Recommendation Report for Planning Permission

REF NO: AW/130/21/PL

LOCATION: 10 Robins Drive
Aldwick
PO21 3BL

PROPOSAL: Part change of use of attached annexe from residential to rent for unrelated people. This site is in CIL Zone 4 (Zero Rated) as other development.

PLAN OF PLOT WITH WITH ANY ALTERATIONS NECESSARY TO CONVERT TO ANNEX

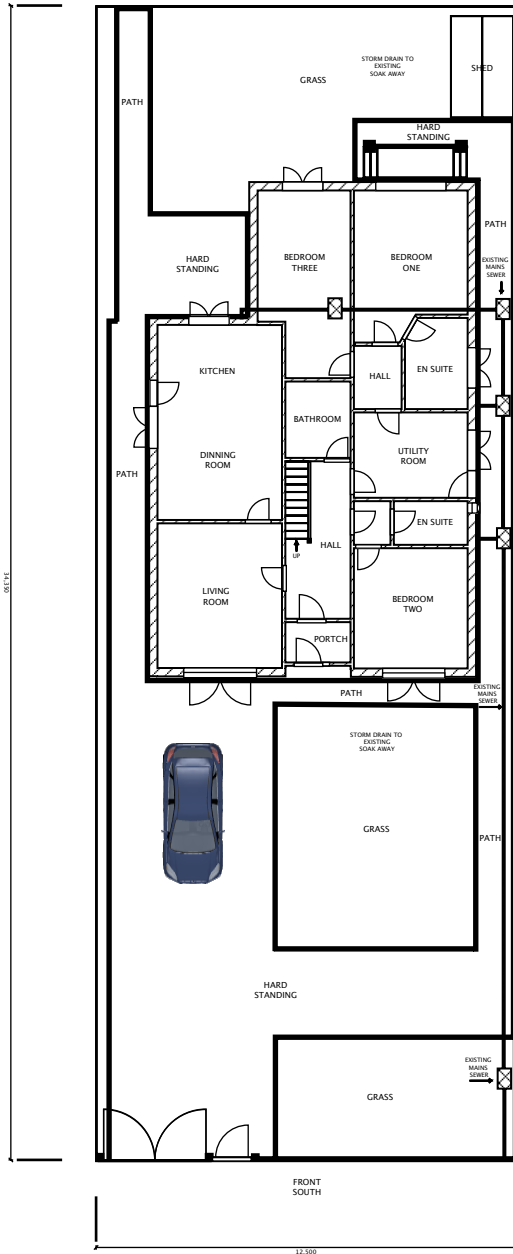
The rear garden will be separated with a fence to form 2 enclosed amenity areas for the proposed and existing dwelling.

Policy H.04 of the Arun Design Guide SPD advises that outdoor amenity spaces should be of an appropriate size and shape and be usable and enjoyable. It states rear gardens should have a minimum depth of 10.5m and buildings should be set back by 2m from the plot boundary to mark defensible space.

The gardens have a limited plot depth and overall plot sizes. The proposed unit has an external space with a width of 8m and a depth of around 5m. The proposed does not accord with the generally expected 10.5m garden length referred to in the guidance, however for a 1 bed property is acceptable. It does however result in the garden of the host dwelling being reduced to an unacceptable size ,with a width of around 4m. The garden retained for the host dwelling is considered to be of a poor size which as a result of the division, is no longer comparable to that of the surrounding area and is no longer sufficient for a dwelling of 3 bedrooms.

The proposal is considered to result in a cramped form of development for the future occupiers of the proposed unit and the occupiers of the host dwelling which has been reduced in size. The development would therefore conflict with policy D DM1 and QE SP1 of Arun Local Plan.

The ADC Parking Standards for a 1 bed property in this type of location (Parking Behaviour Zone 2) requires an expected level of 2 car parking spaces on site. The plot plan demonstrates 1 space for the annexe and 1 space for the host dwelling. Whilst the front garden is relatively large and may be able to accommodate more, the parking provided does not comply with the guidance or TSP1 of the Plan.

PLAN WITH WITH ANY ALTERATIONS NECESSARY TO CONVERT TO ANNEX

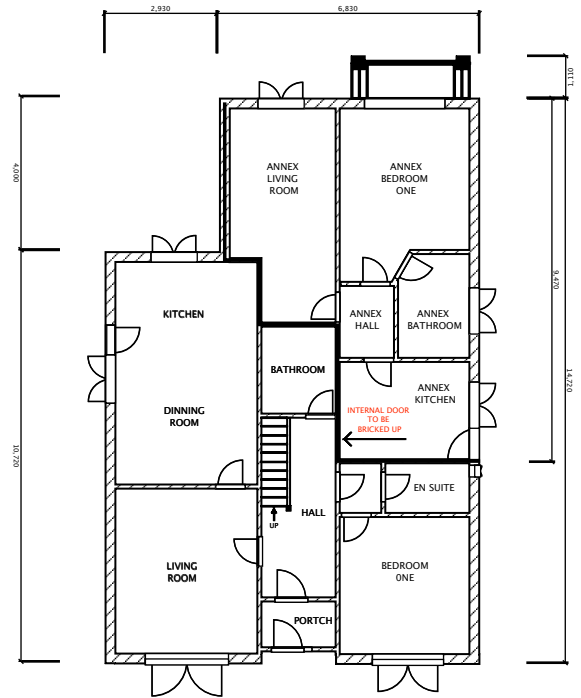
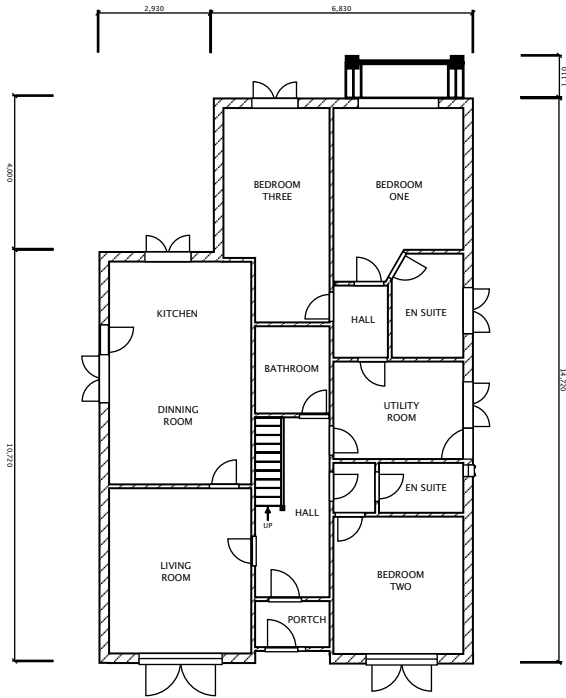
The escape route from the Annexe living room and Annexe bedroom appears to be via the kitchen, which would be unacceptable as the sole means of escape. This can be overcome by ensuring that the windows in the Annexe living room and Annexe bedroom meet the requirements of escape windows. Where escape windows are fitted, care must be taken to ensure they are of adequate size, they open to level and unobstructed areas and lead to a place of ultimate safety. Where escape windows are fitted, care must be taken to ensure they are of adequate size, they open to level and unobstructed areas and lead to a place of ultimate safety. There should be adequate fire separation between the main house and the Annexe. This should be 60 minutes fire resistance horizontally and

vertically. If this cannot be achieved, an interlinked fire alarm and detection system must be installed to provide coverage and warning between the two dwellings.

The floor area measures approximately 49.37m² and whilst it measures slightly short of 2p standard,

taking into error from the measurement tools, this figure is acceptable and complies with the guidance.
